From: Michael Eastham <Michael.Eastham@arun.gov.uk>
Sent: 03 June 2020 18:10
To: Planning.Responses <Planning.Responses@arun.gov.uk>
Subject: LU/90/20/DOC - PARCELS A2 & B6, Littlehampton - Drainage Drawings

Please upload onto Ocella the email below which is the revised consultation response from **ADC Drainage Engineers** to discharge of condition application **LU/90/20/DOC**.

Subject: RE: 2020-05-15-19163-PARCELS A2 & B6, Littlehampton - Drainage Drawings

From: Clark, Robert [REDACTED]
Sent: 15 May 2020 10:27
To: Michael Eastham <Michael.Eastham@arun.gov.uk>; Paul Cann <Paul.Cann@arun.gov.uk>
Subject: 2020-05-15-19163-PARCELS A2 & B6, Littlehampton - Drainage Drawings

Flow Control Chamber HB1

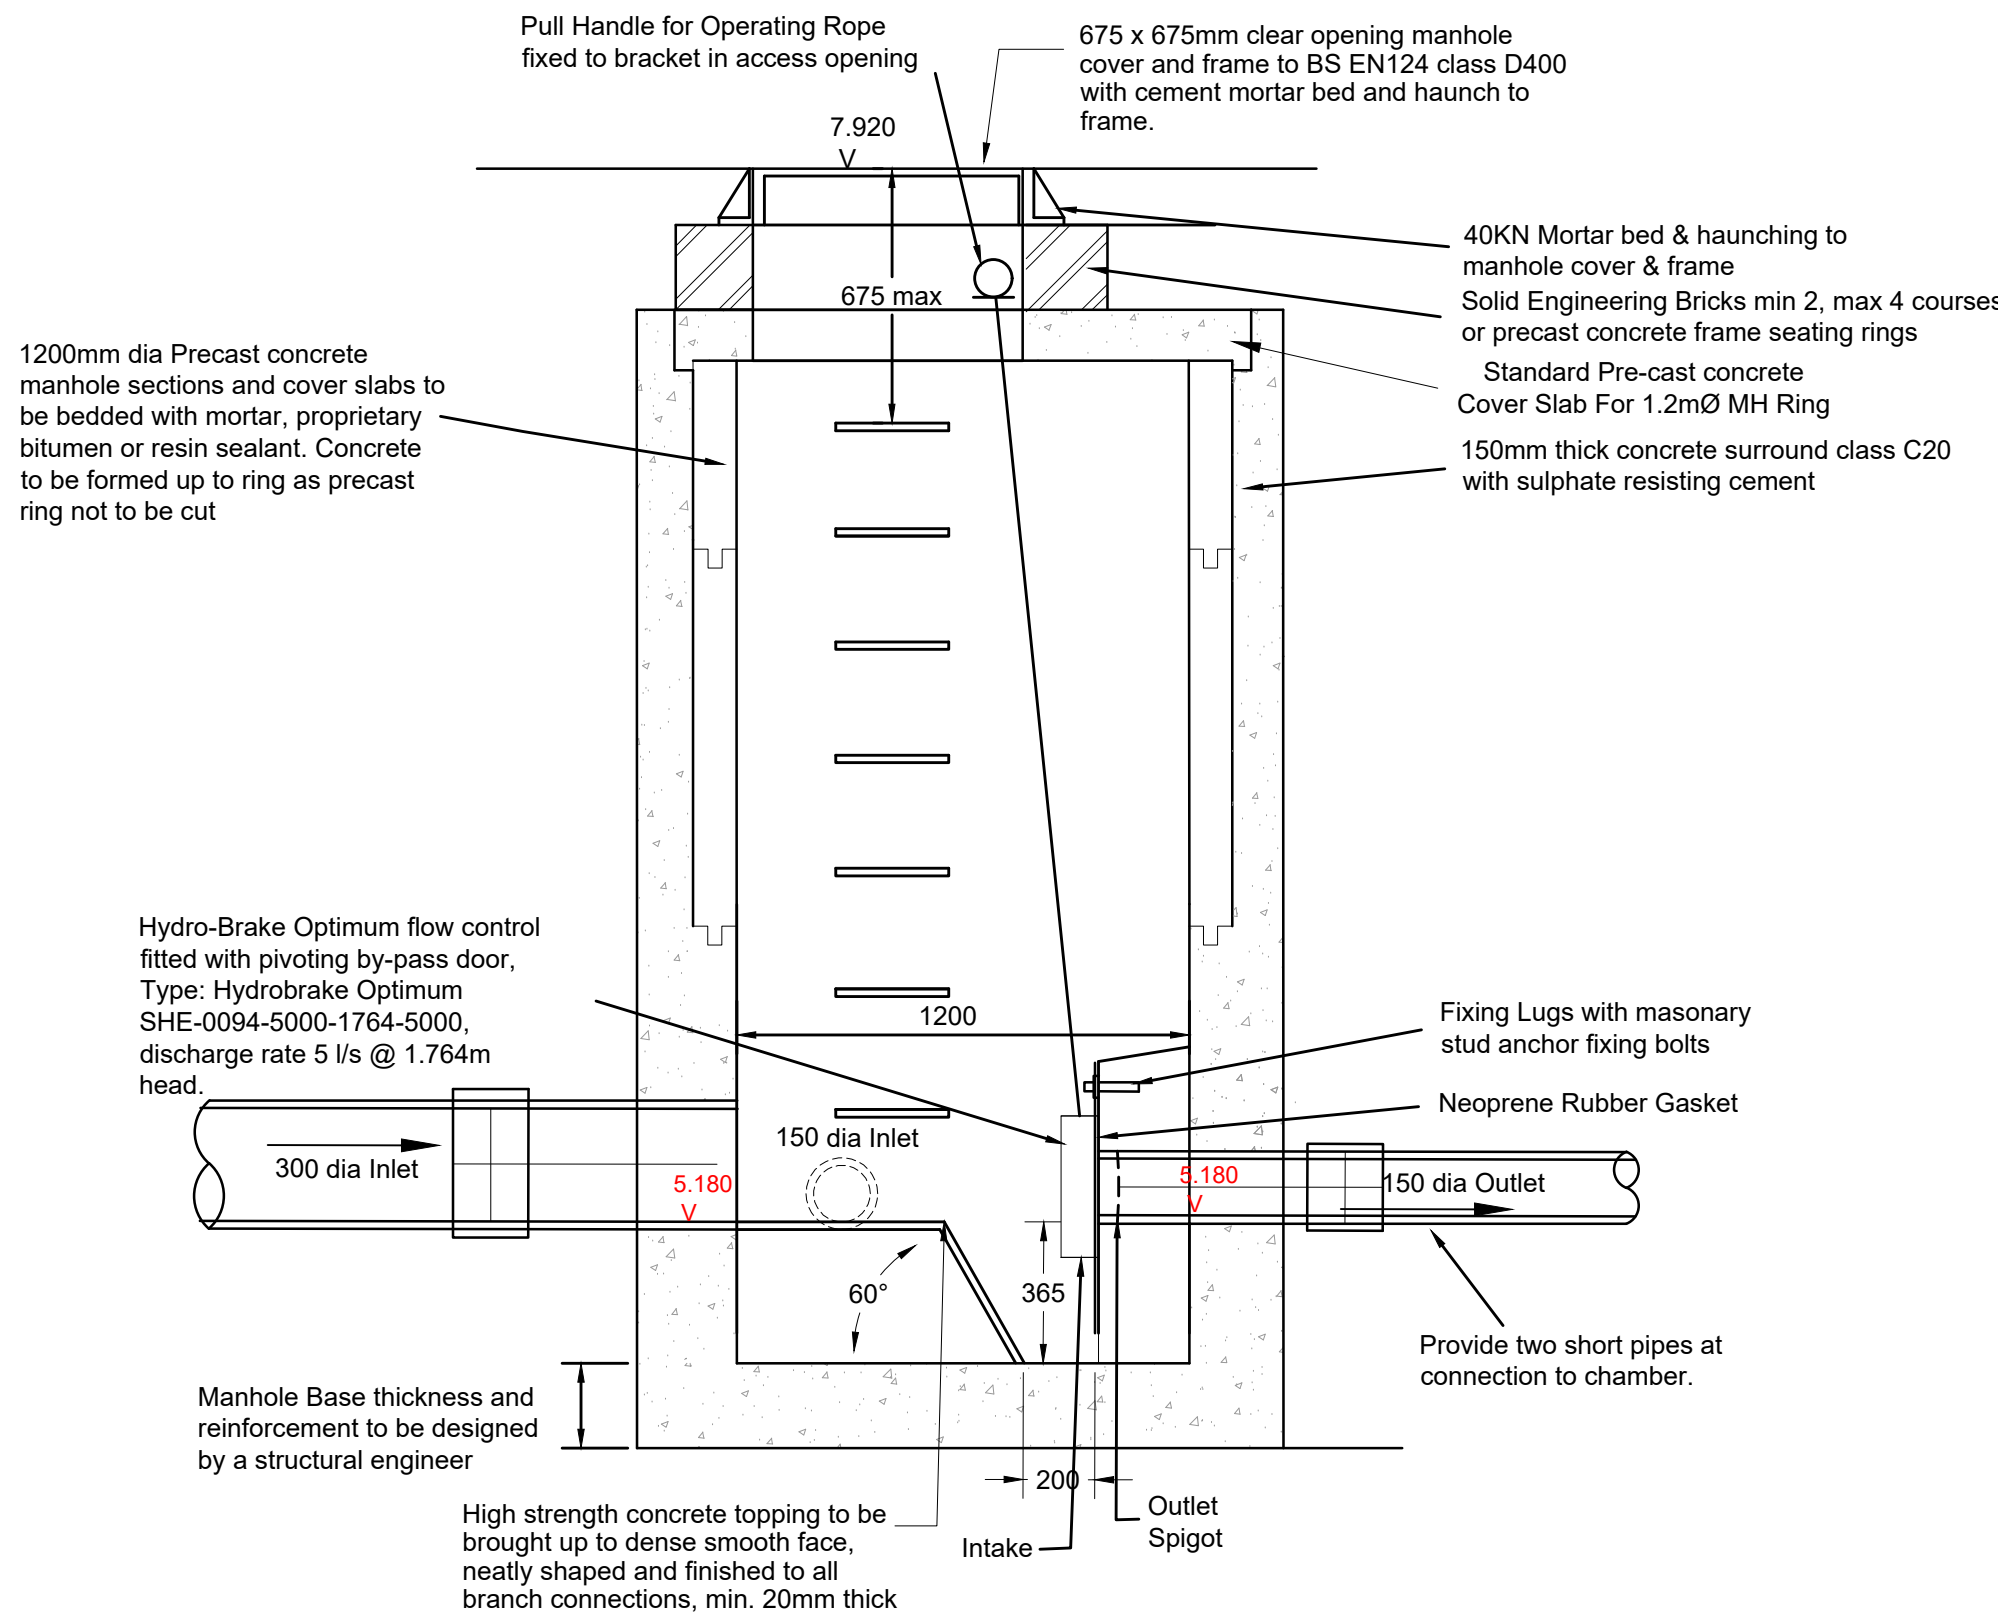
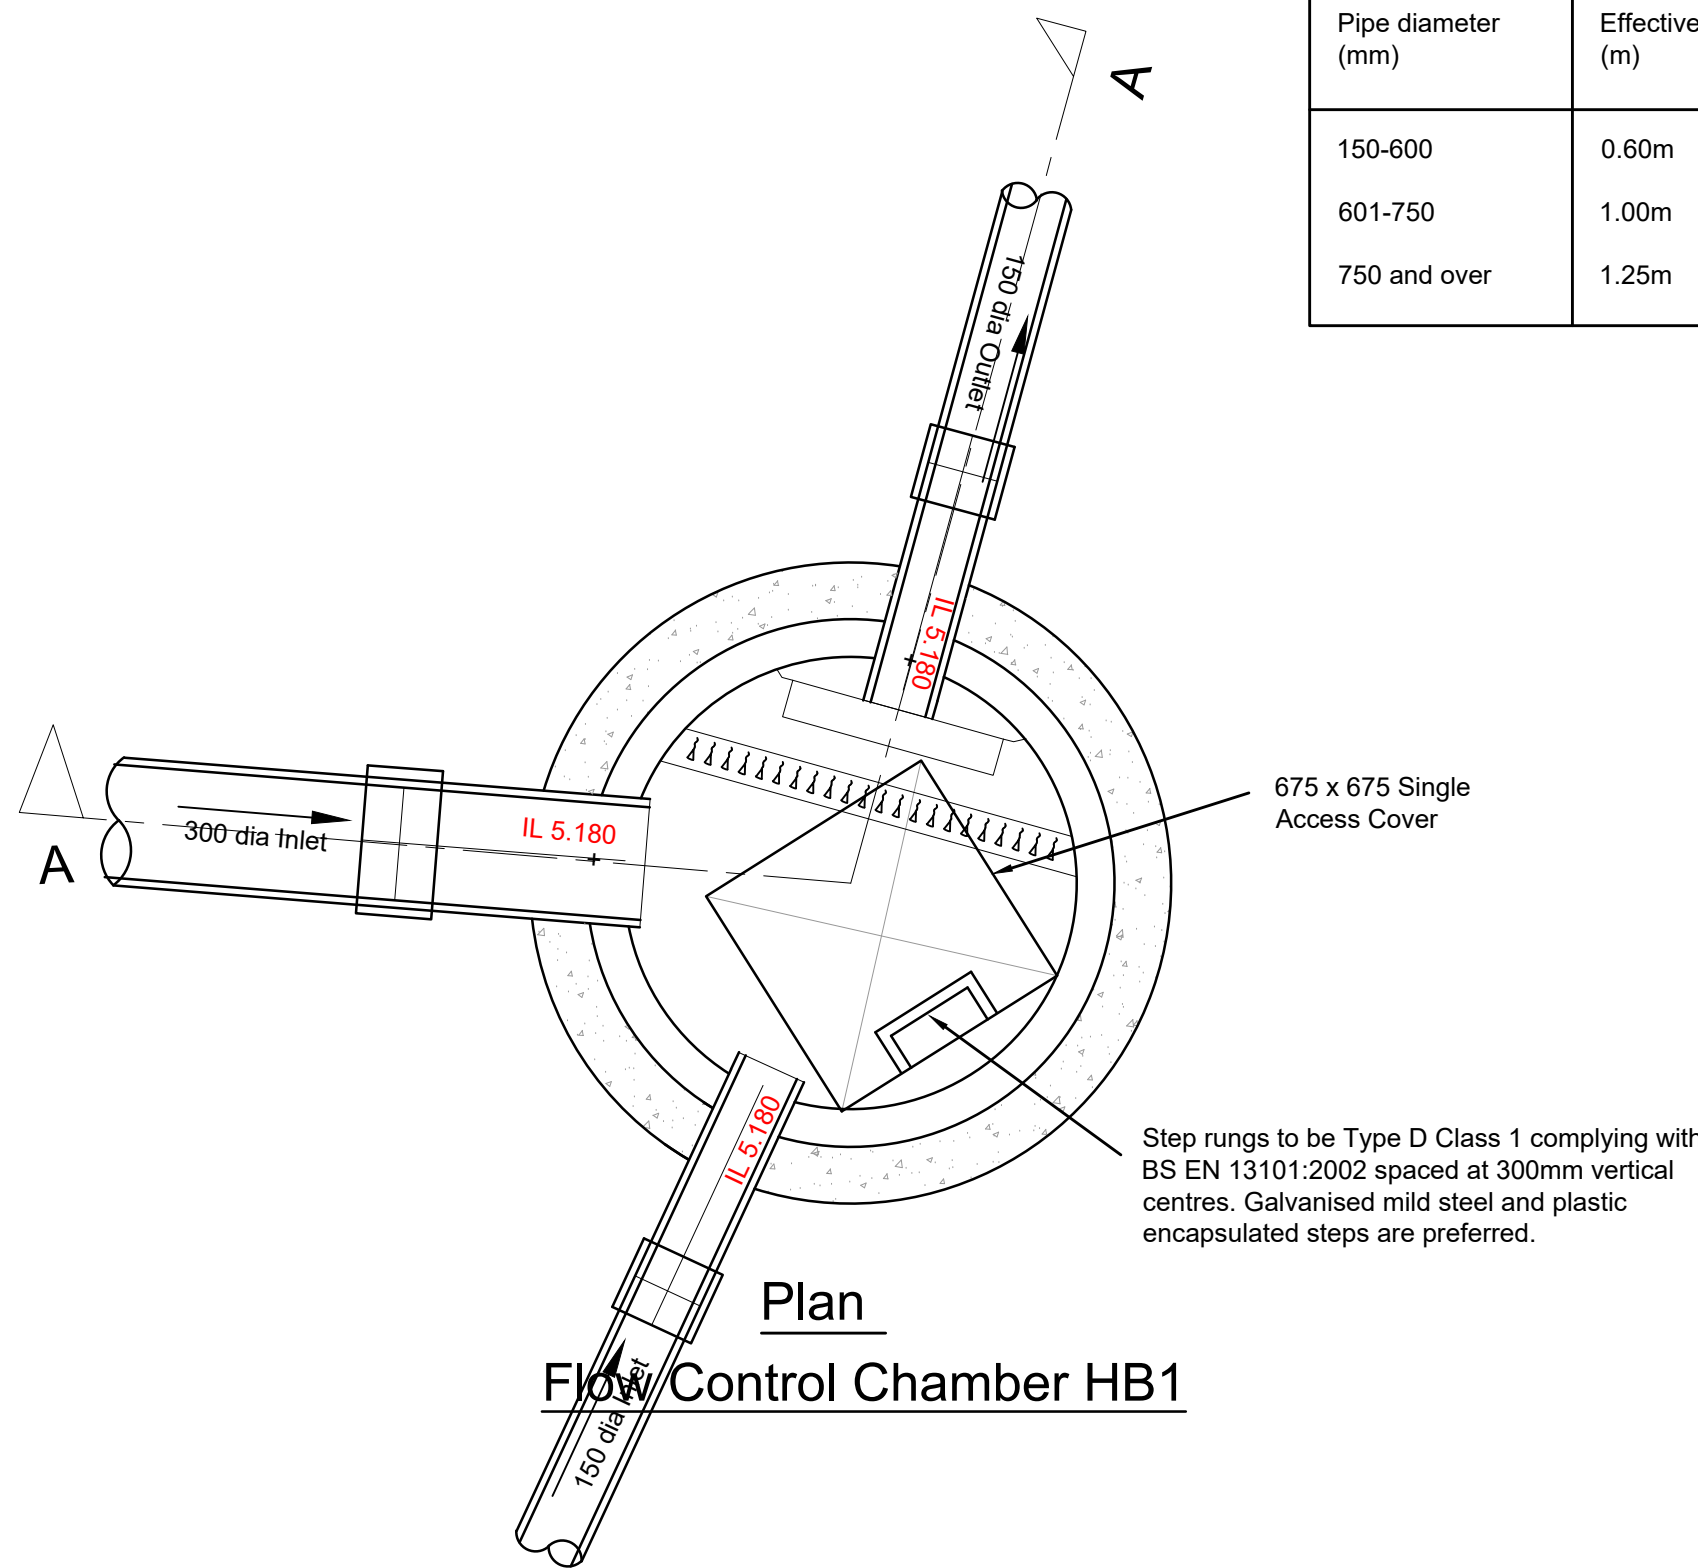
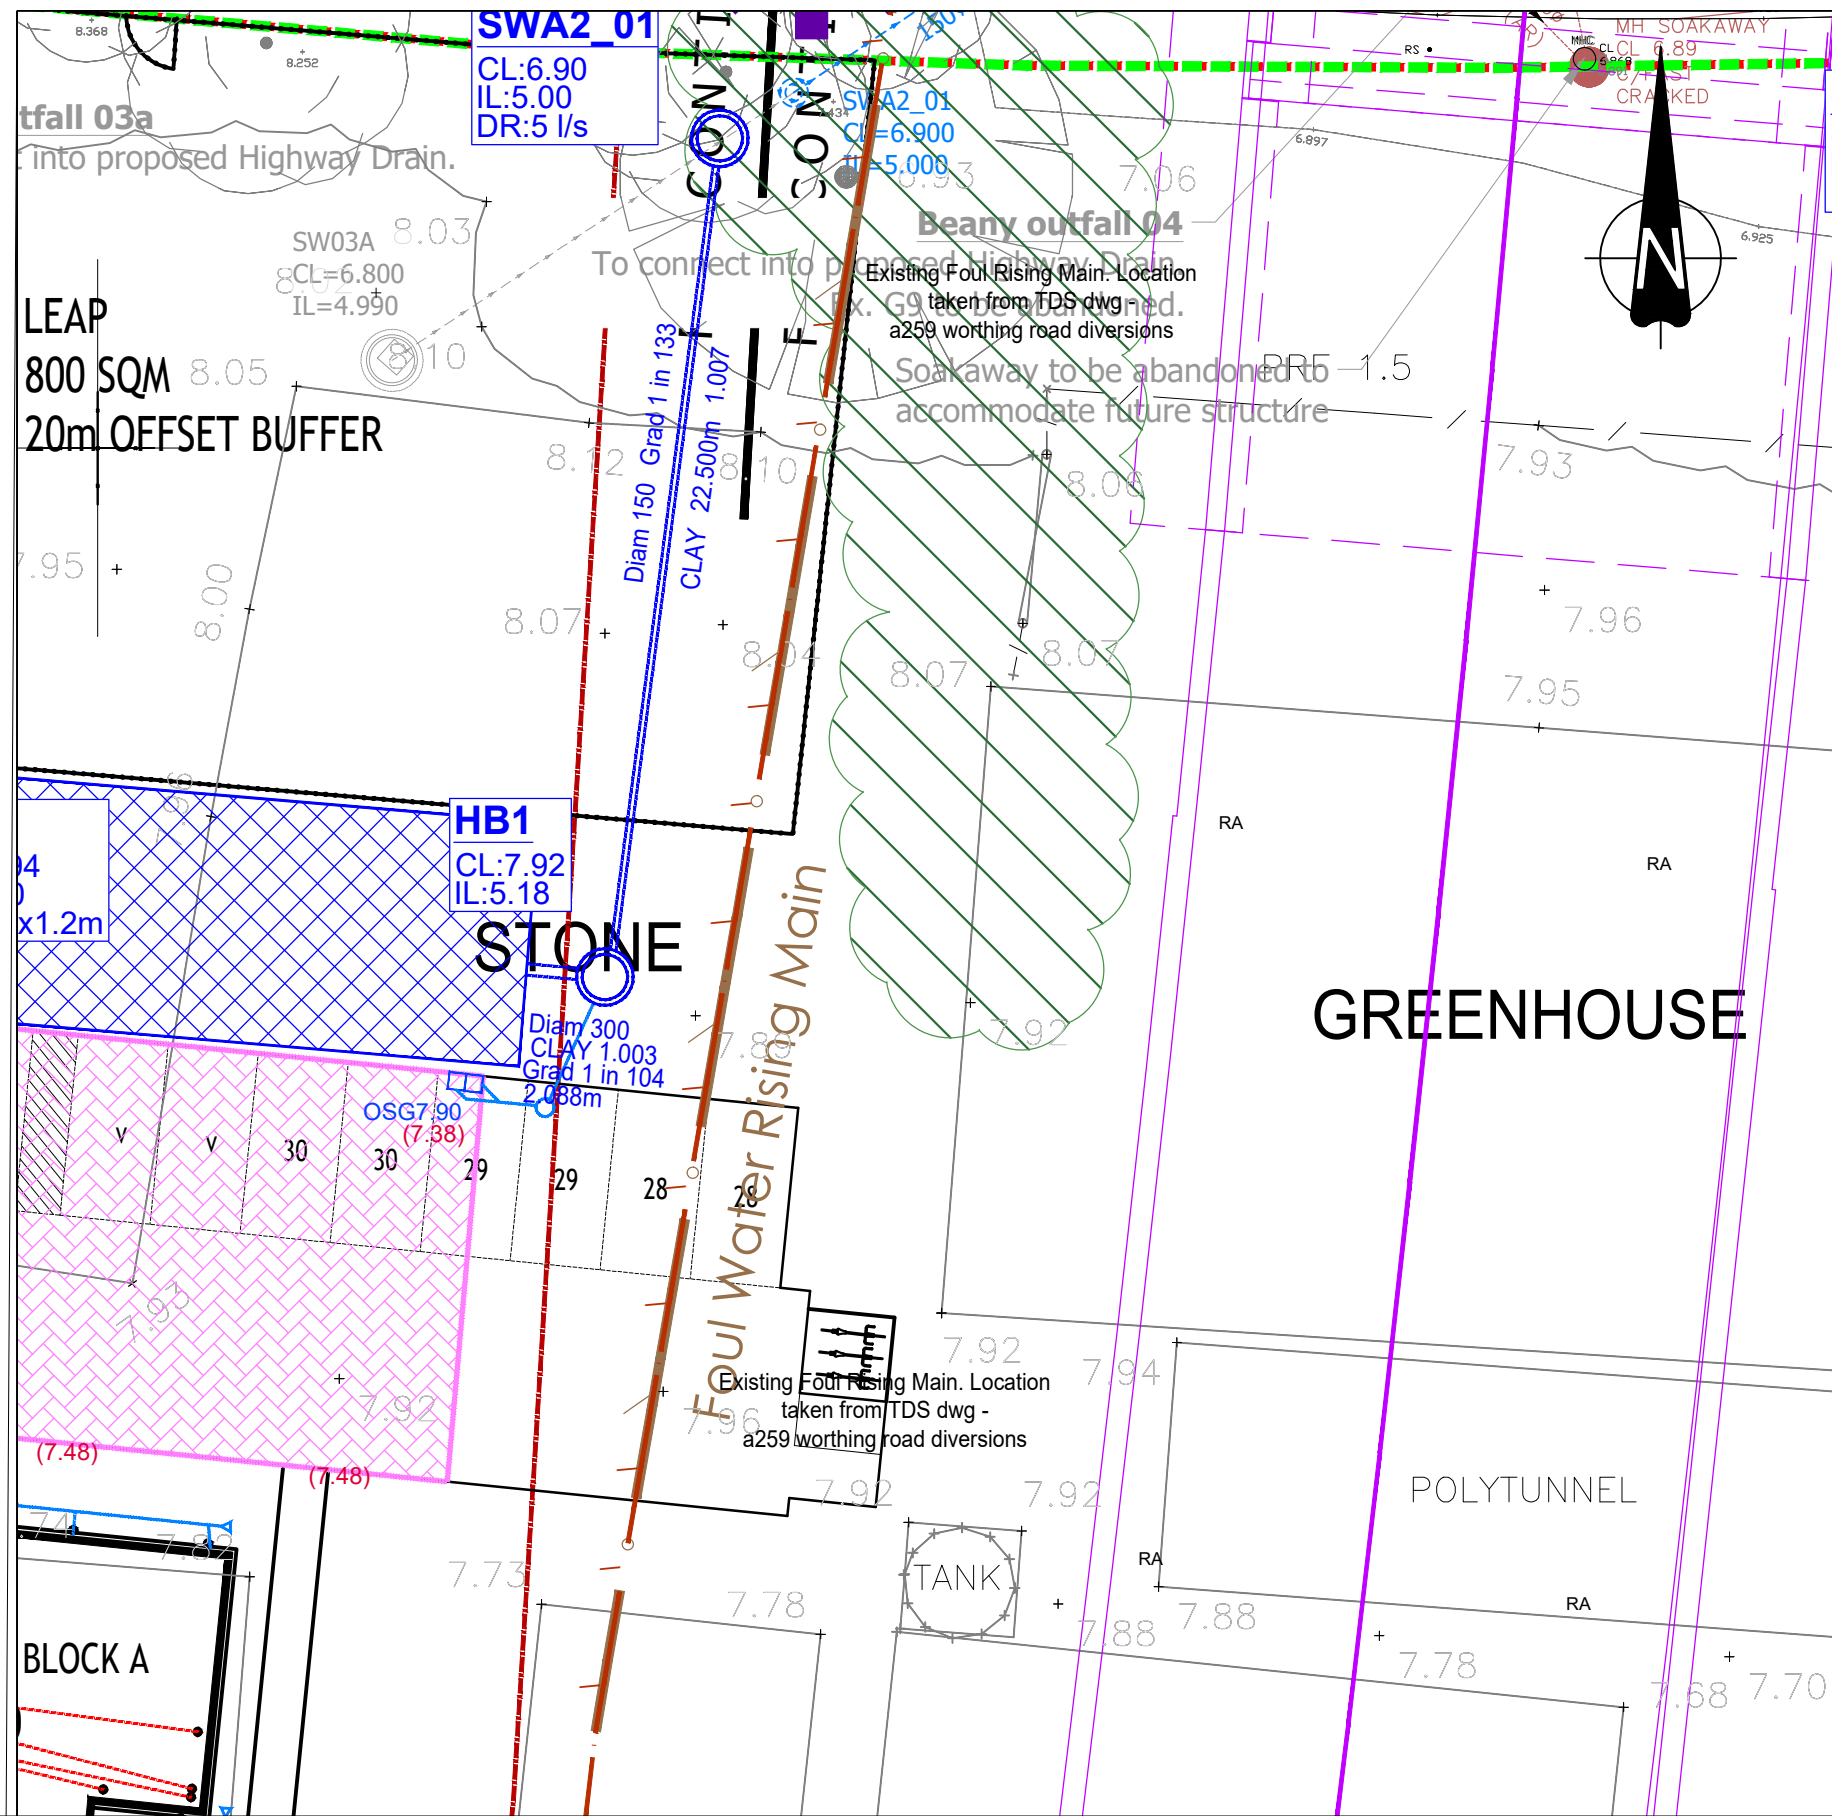
3. Provide channel drain construction details/spec. *ok*
4. Hydrobrake chamber HB01 construction detail – connect incoming 150mm connection from permeable paving at soffit to soffit level with 300mm pipe inlet. *ok*
